Responses to ExA's First Written Questions

River Humber Gas Pipeline Replacement Project

Annexure 2 to Response to First Written Questions – Q5.5 Areas Plan

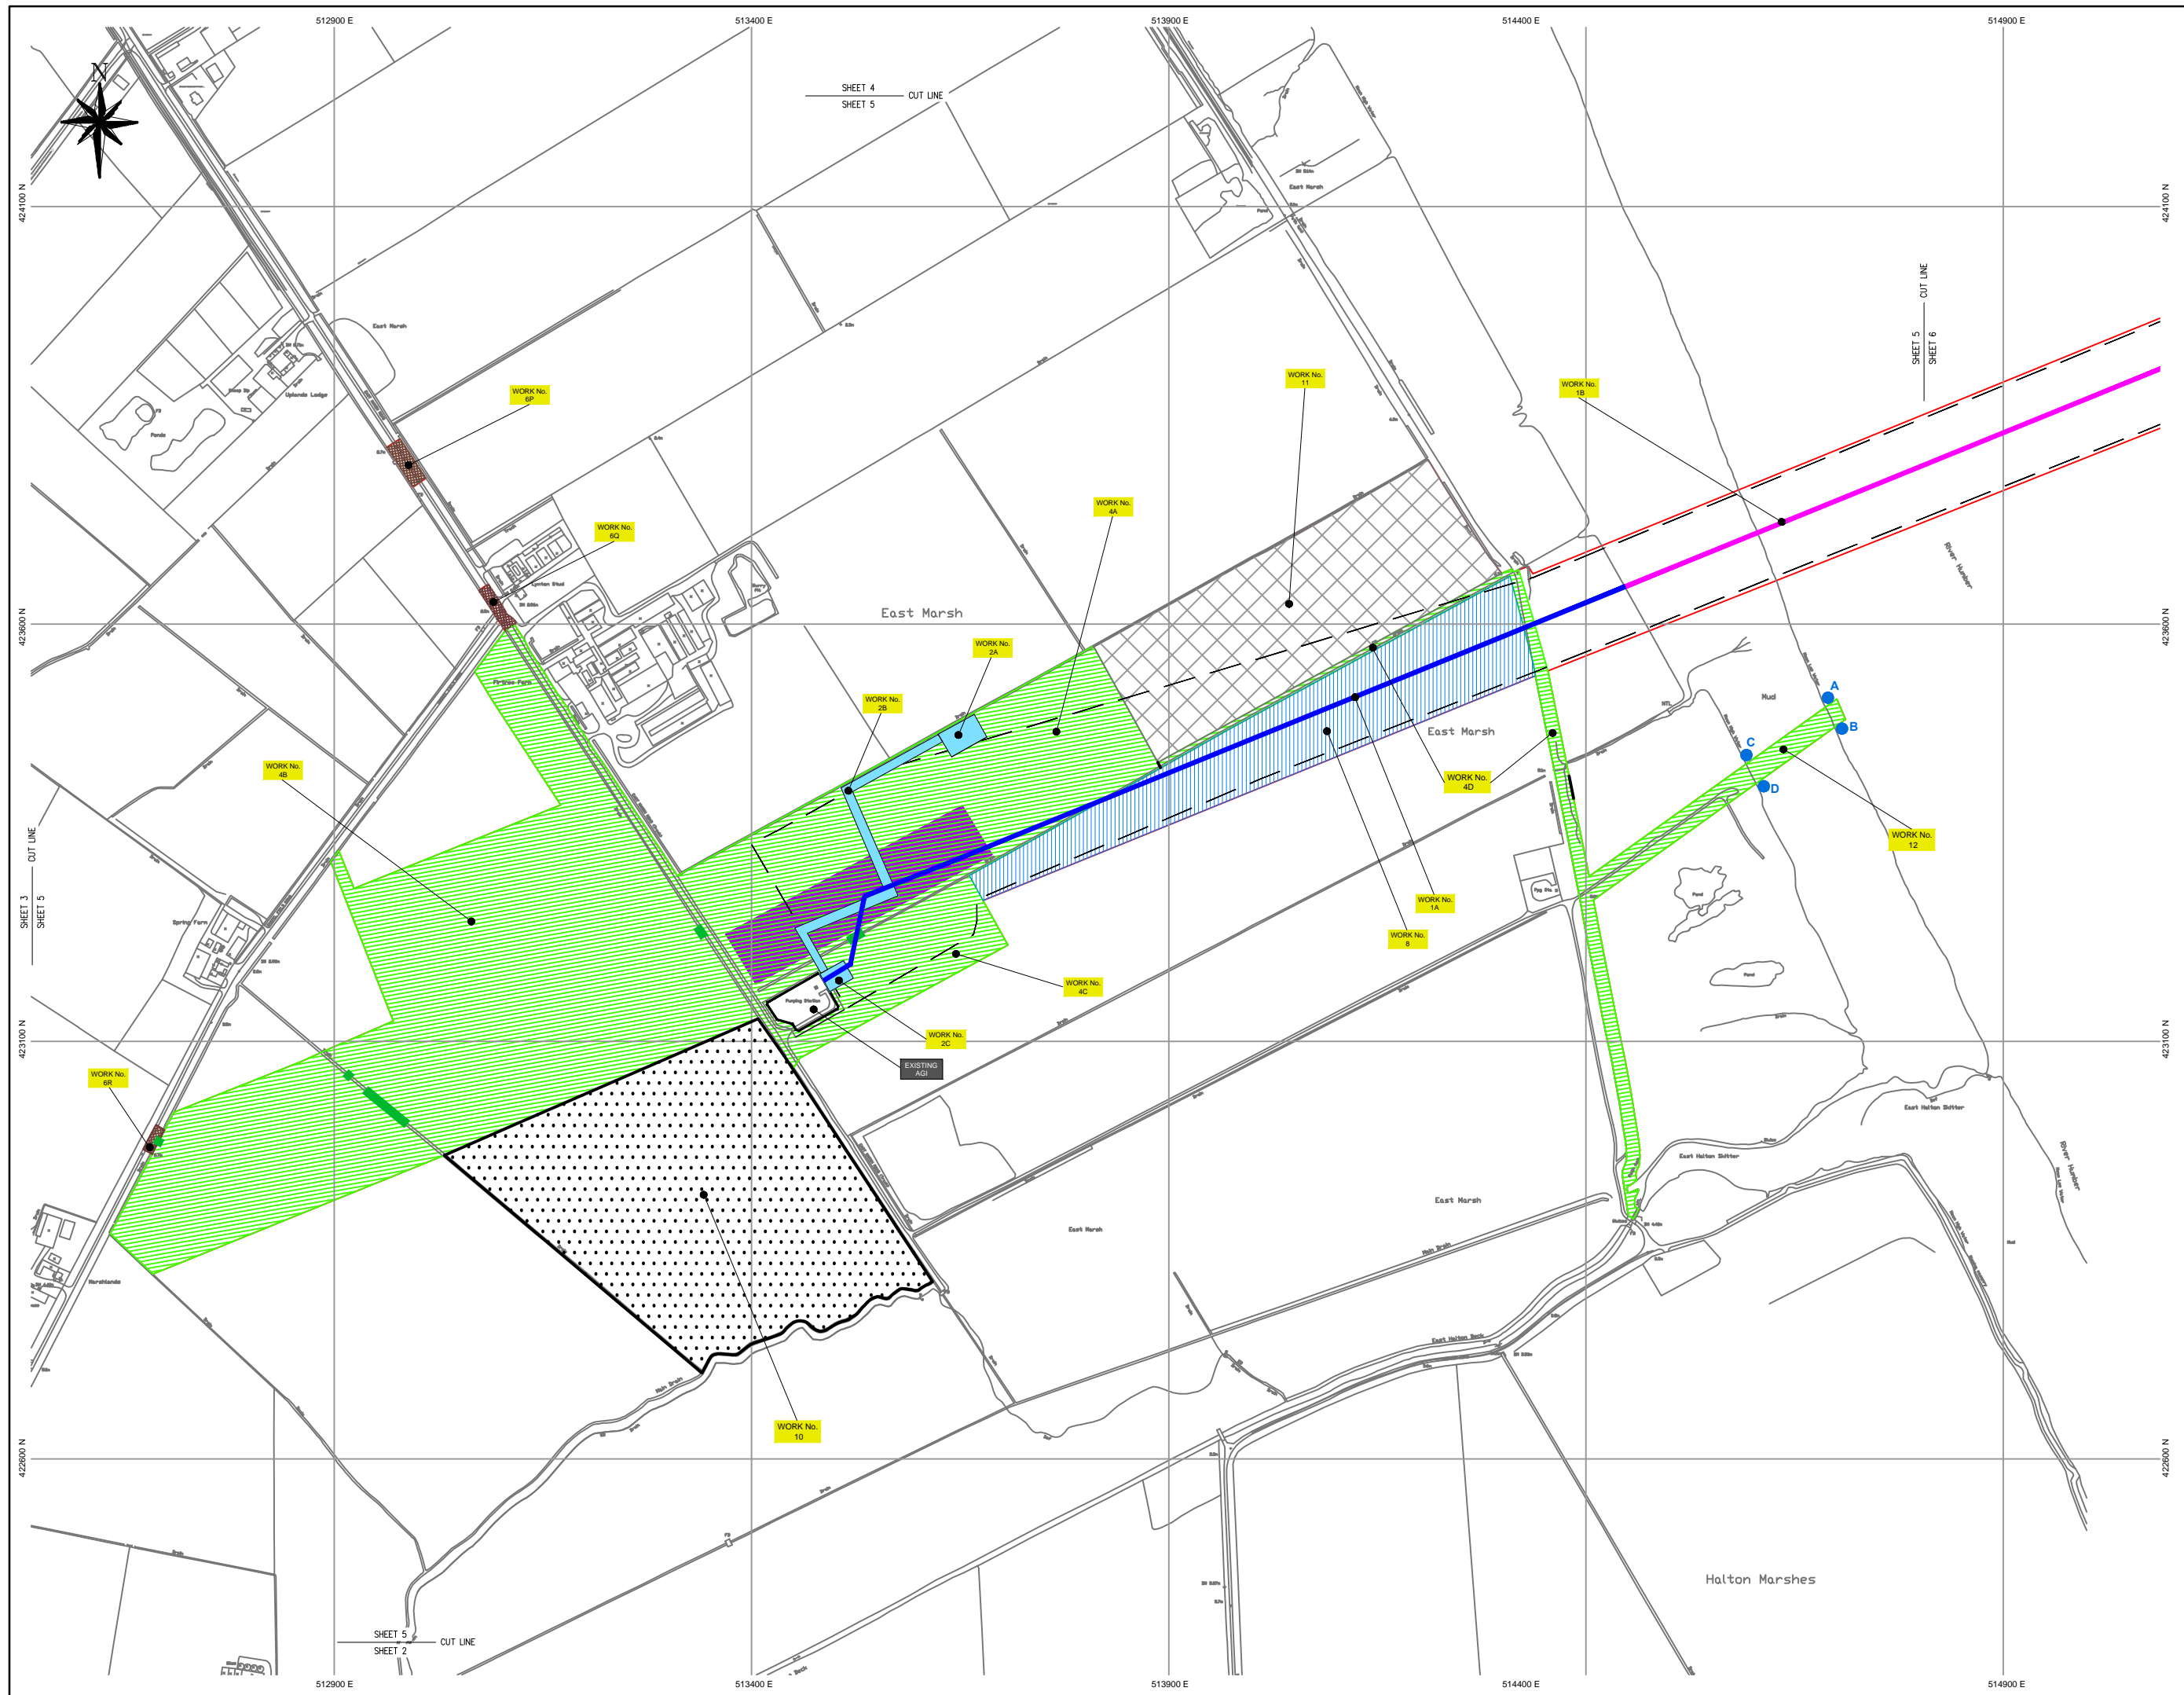
5.5	Applicant	<p>1. By means of a simple table and numbered illustration (plan) please confirm the land areas (Ha) green hatched and grey dotted (temporary spoil) identified on [APP-07] 2.2 Sheet 5 of 8 Works Plans. Include both the areas (ha) within</p>	<p>1. The areas are indicated on Doc 8.9.2 – Annexure 2 to these responses.</p> <p>2. The use of 40ha (rather than 51.3ha) is the area of fields to be temporarily used as a result of</p>

<p>the main construction site and that necessary for pipes and pumps for de-watering and flooding of the tunnel by pumps placed in the intertidal area and temporary spoil storage.</p> <p>2. [APP-027] Para 2.2.5 of the HRA report indicates that approximately 40 ha of arable land in total will be required (Goxhill & Paul). Is the total area required actually 51.3 ha? ([APP-019] Statement of Reasons 20.5 ha [4.2.1] + 12.3 ha [4.2.3] + 12.9 ha [4.3.2] + 1.6 ha [4.5.1] + 2.7 ha [4.6.1] m+ 1.3 ha [4.6.2]= 51.3 ha? Please clarify.</p>	<p>the construction phase of the project (i.e. the amount of foraging/ roosting habitat directly under the footprint of the Project which would not be available for Special Protection Area bird species for the duration of the works). This figure does not include existing infrastructure such as the Above Ground Installations, and the area of set aside at Goxhill (Works No. 11).</p>

RIVER HUMBER GAS PIPELINE REPLACEMENT PROJECT		
INDICATIVE PAULL SITE LAYOUT FIGURE 2.4 B		
REFERENCE		
DRAWN	CHECKED	APPROVED
JN	KB	NH
SCALE	ORIG SIZE	SHEET
1 : 1000	A1	1 of 1
DATE		REVISION
12 OCT 15		03

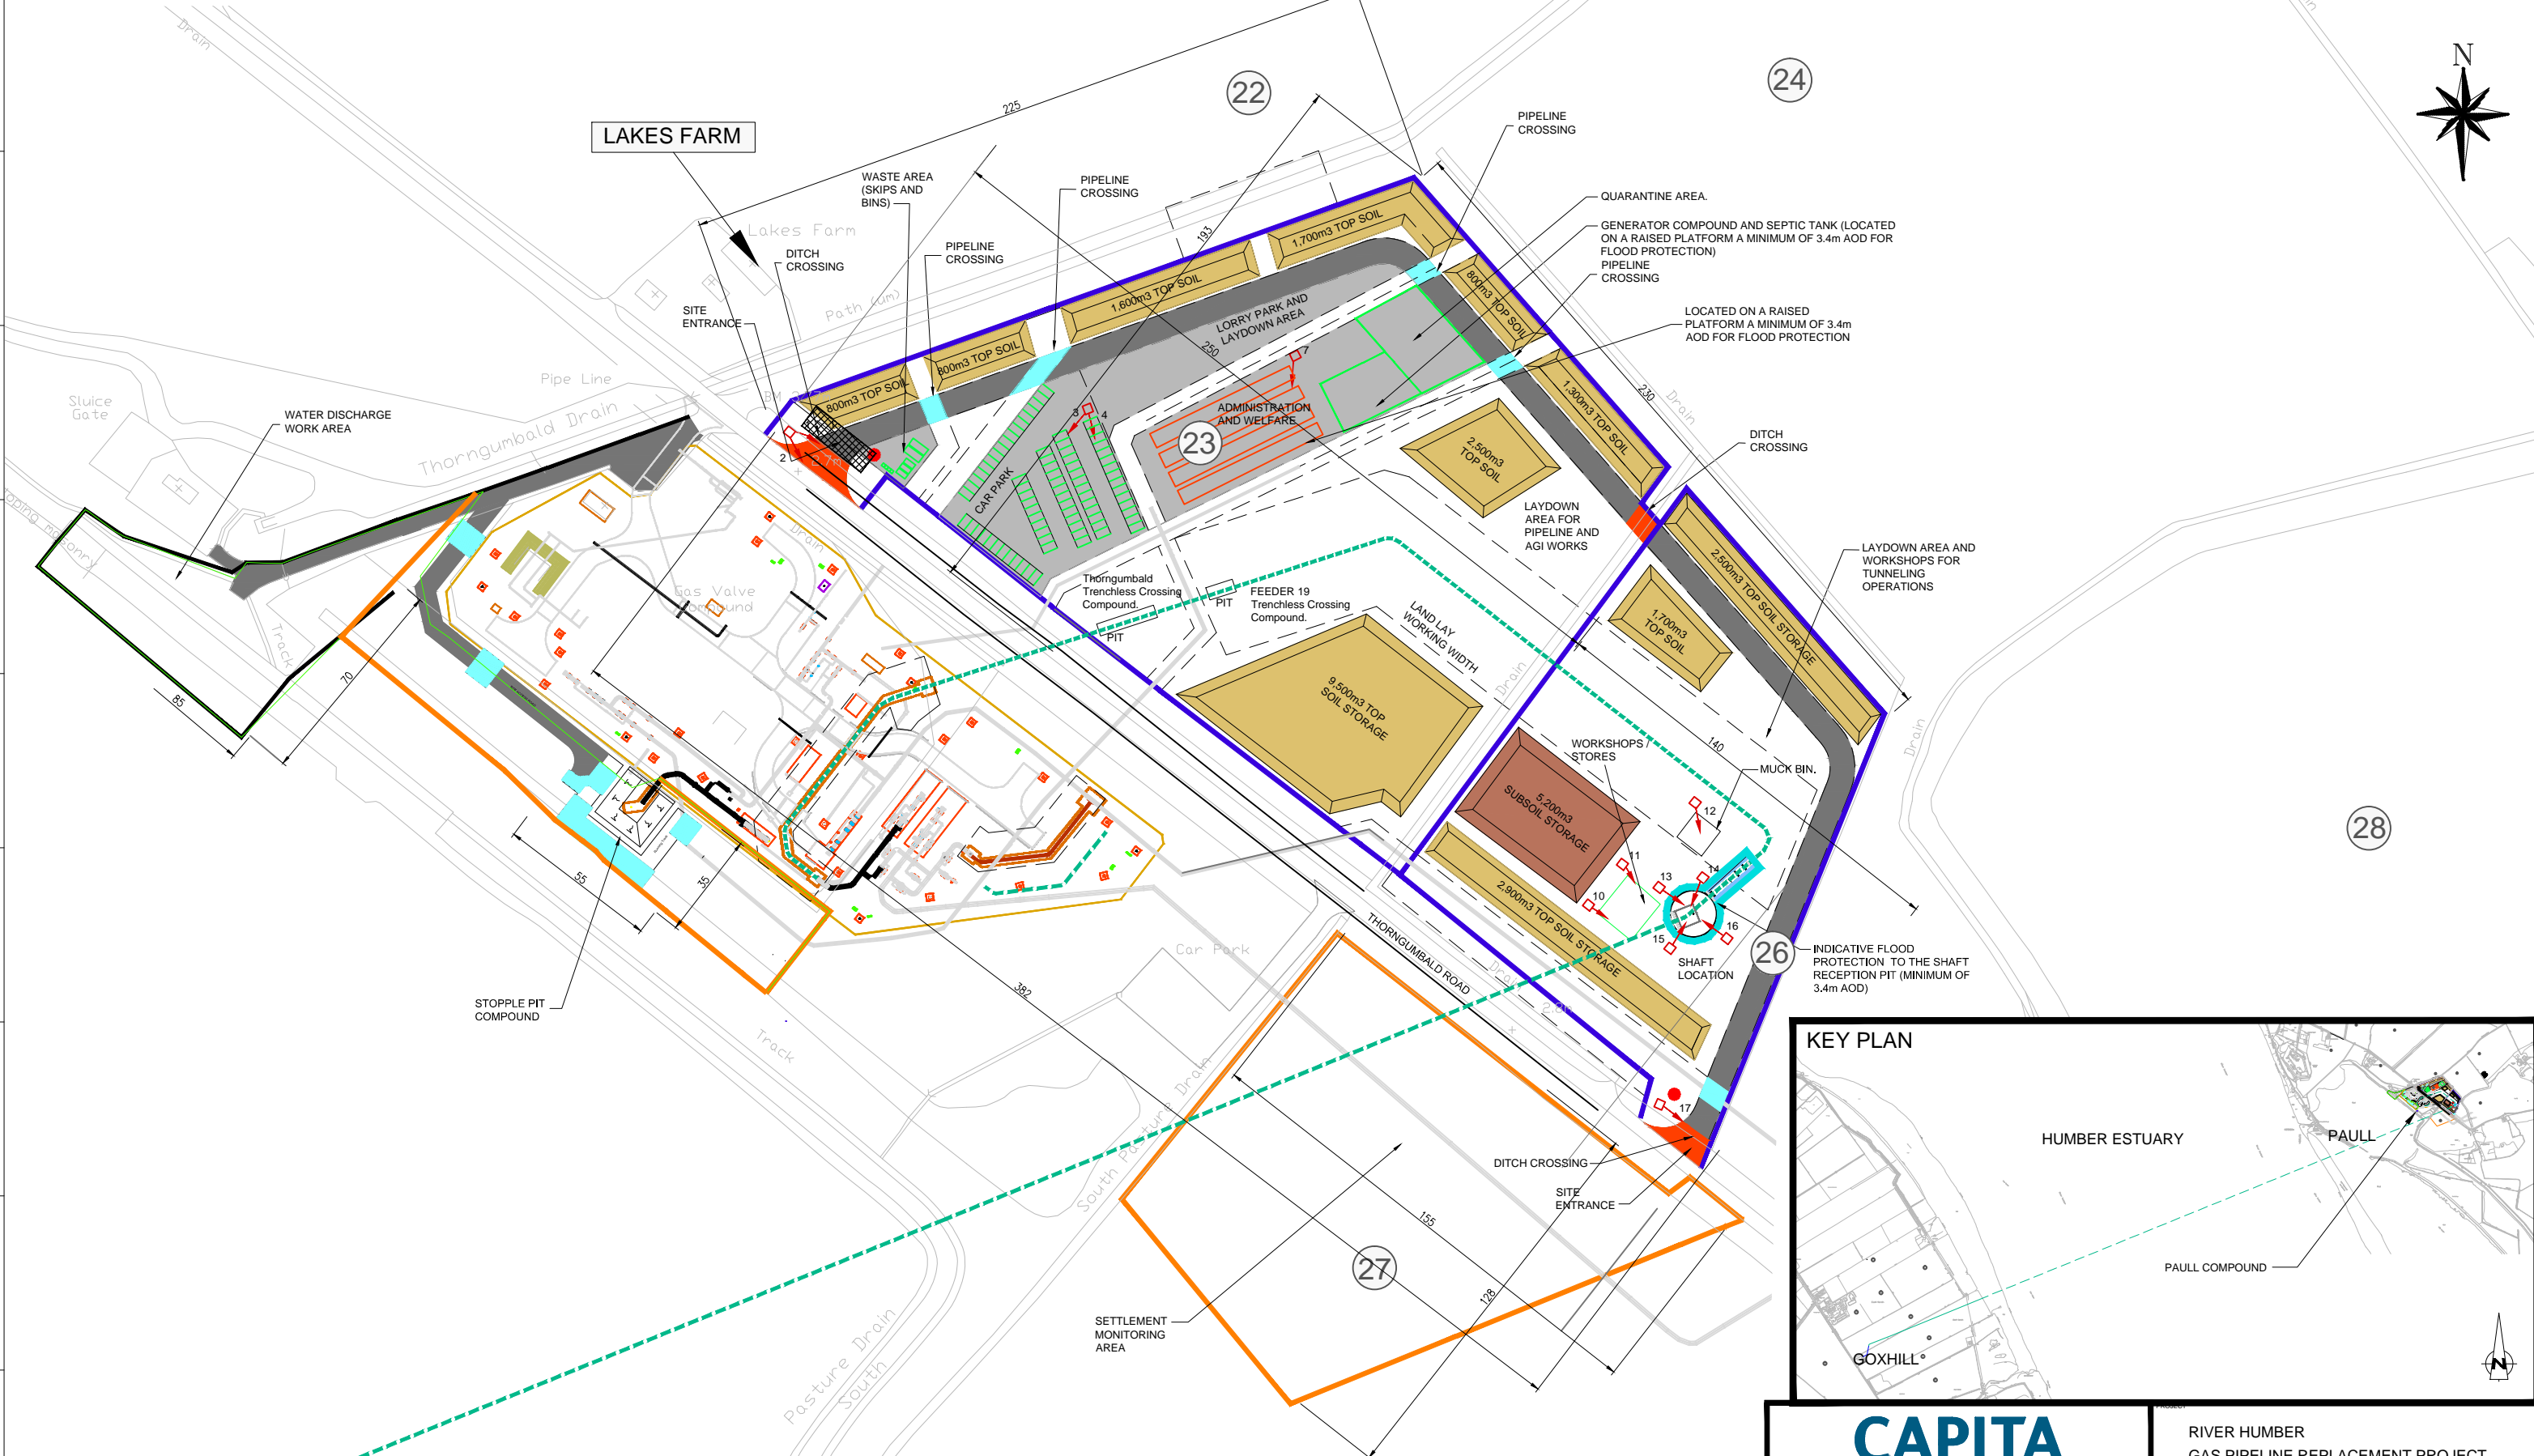
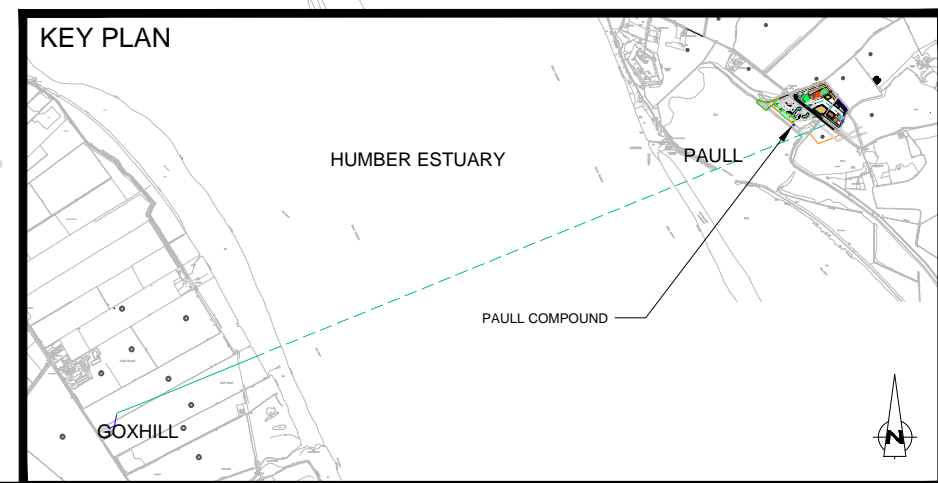
1.5	Applicant	Please illustrate the location of the cathodic protection kiosks, Work No 2C (Goxhill) and Work No 3B (Paull) on the Site Layout Plans [APP-09] and supply updated drawings.	Updated Site Layout Plans showing the limits of deviation for these areas are included with our deadline 2 submissions (Doc 2.4B). The precise locations will be subject to detailed design by the main works contractor.
